KIRKLEES METROPOLITAN COUNCIL INVESTMENT & REGENERATION SERVICE

DELEGATED DECISION TO DETERMINE PLANNING APPLICATIONS

Reference No:	2025/62/90752/W
Site Address:	29, Cliff Road, Holmfirth, HD9 1UY
Description:	Erection of single storey front extension, replace existing balcony, external changes to windows and internal alterations outbuilding to front with parking above and associated works.
Recommending Officer:	Molly Storer

Officer Report.

SOUTH ELEVATION

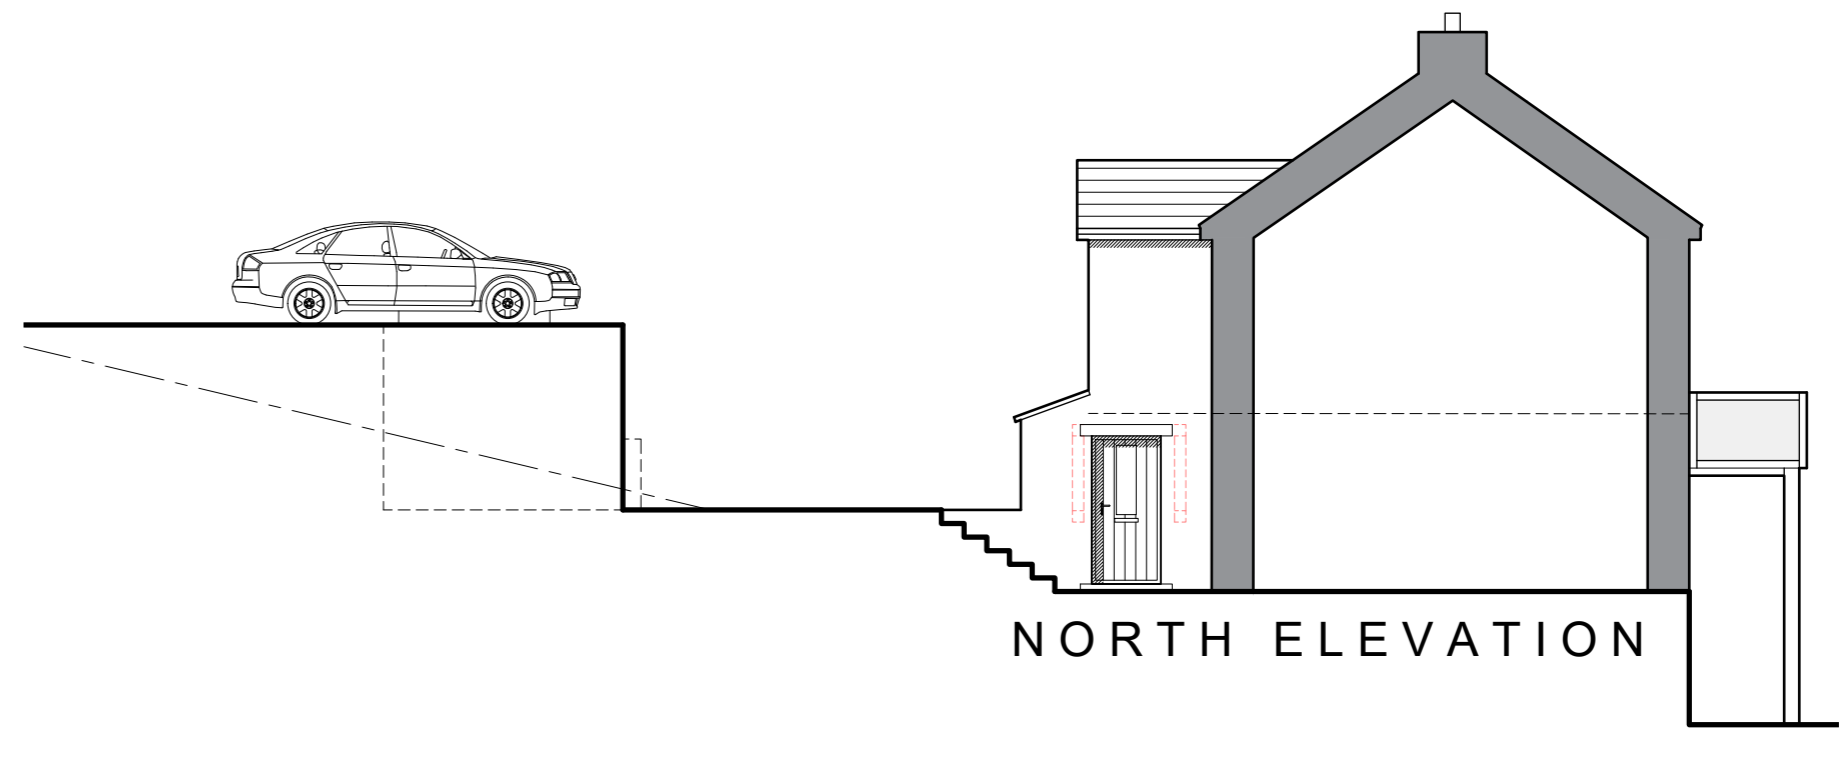
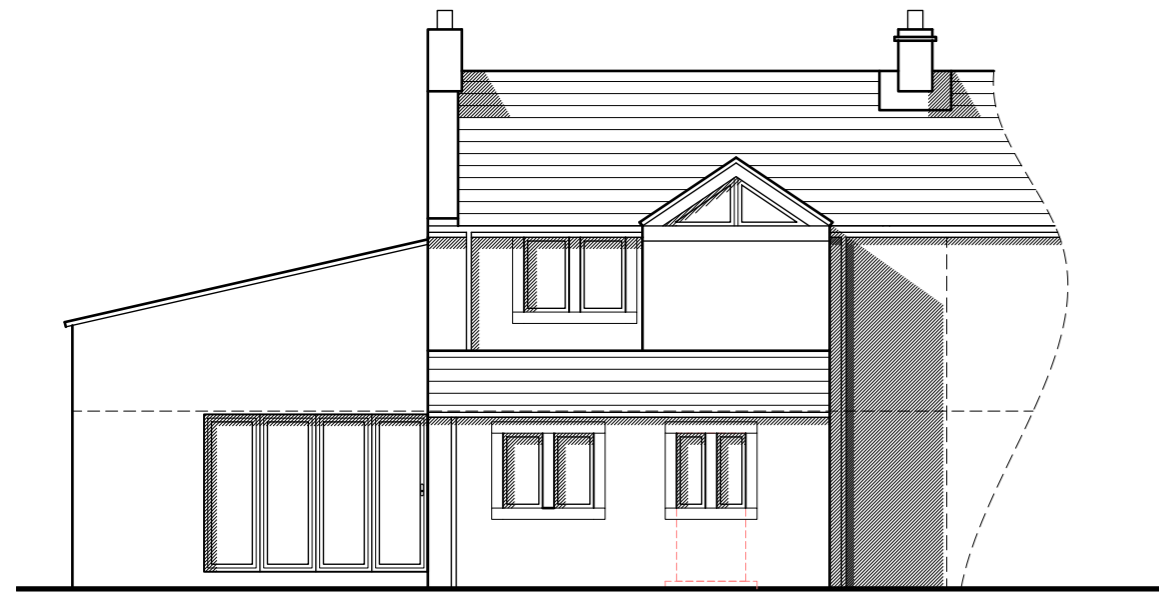
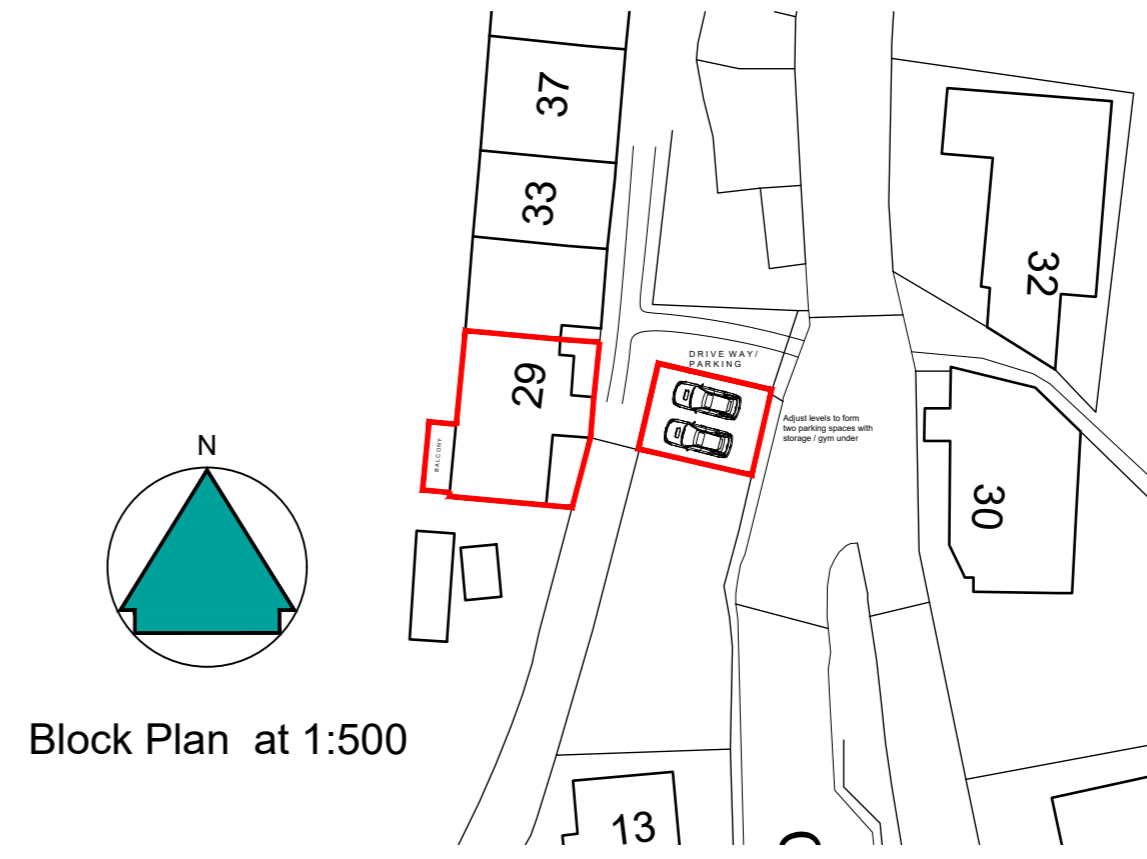
In this instance there is already an existing balcony to the rear of the property. Although this will extend beyond the rear elevation it is concluded that with a condition requesting privacy screens to either side that the balcony will not result in any undue privacy concerns. The design of the balcony is lightweight and will not harm the appearance of the house or wider area.

The balcony will maintain a separation distance of 6m to this property and will be considered to have a privacy screen to the side elevation in any case.

4. A 1.8m high privacy screen shall be installed on the north and south side elevations of the balcony before the balcony is first brought into use. The 1.8m high privacy screens shall thereafter be retained.

UNDER PARKING FLOOR PLAN

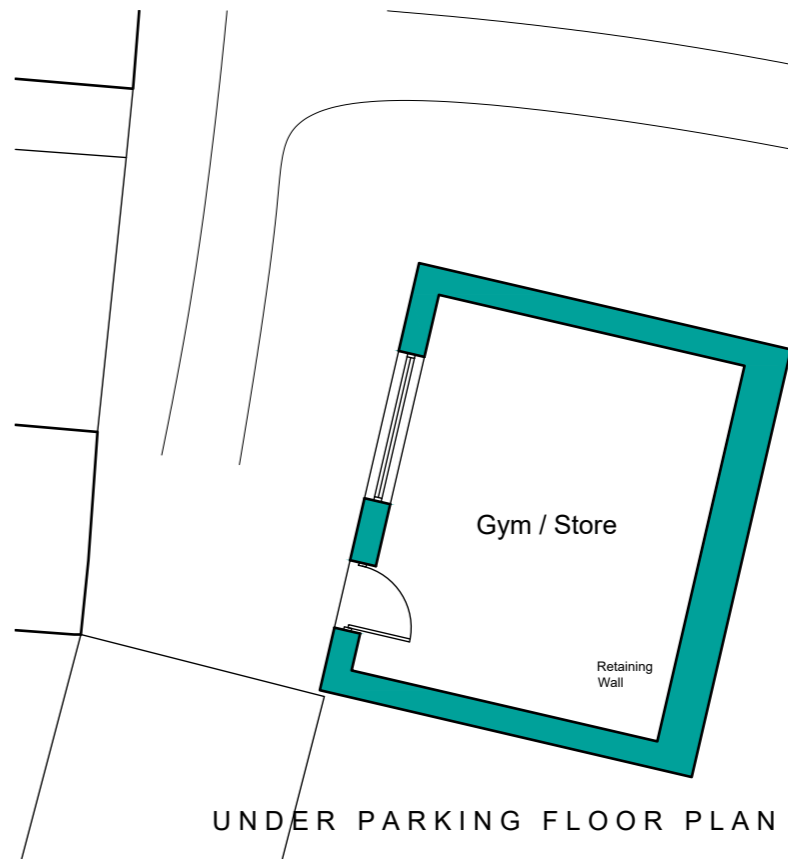
Highway Structures - The proposed single story extension is not considered to impact the adjoining highway, however, the proposed construction of an underground Gym/ Store adjacent to Cliff Road may do so and therefore a fully dimensioned X-sectional detail for this area was requested. The agent sent this plan and the Highways Structures team stated they could now support the application subject to a condition.

Due to the nature of the proposal the highways structures team were formally consulted. They stated that the proposed single story extension is not considered to impact the adjoining highway, however, the proposed construction of an underground Gym/ Store adjacent to Cliff Road may do so and therefore a fully dimensioned X-sectional detail for this area was requested. The agent sent this plan and the structures team stated that although the design of proposed building extension and the retaining wall to the underground gym are considered exempt from a technical approval, the proposed extension of the off-street parking will require modifications to the existing burr wall

supporting Cliff Court and as such these works will be liable to a formal technical approval. Therefore, a condition was recommended that the development shall not commence until a scheme has been submitted to, and approved in writing by, the Local Planning Authority which relates to the partial demolition and/or modification of the existing burr wall supporting Cliff Court and the associated modification of ground levels.

3. Development shall not commence until a scheme has been submitted to, and approved in writing by, the Local Planning Authority which relates to the partial demolition and/or modification of the existing burr wall supporting Cliff Court and the associated modification of ground levels. The submitted scheme shall include a timescale for completion of the works. The development shall be undertaken, and the works completed, in accordance with the approved scheme which shall thereafter be retained.
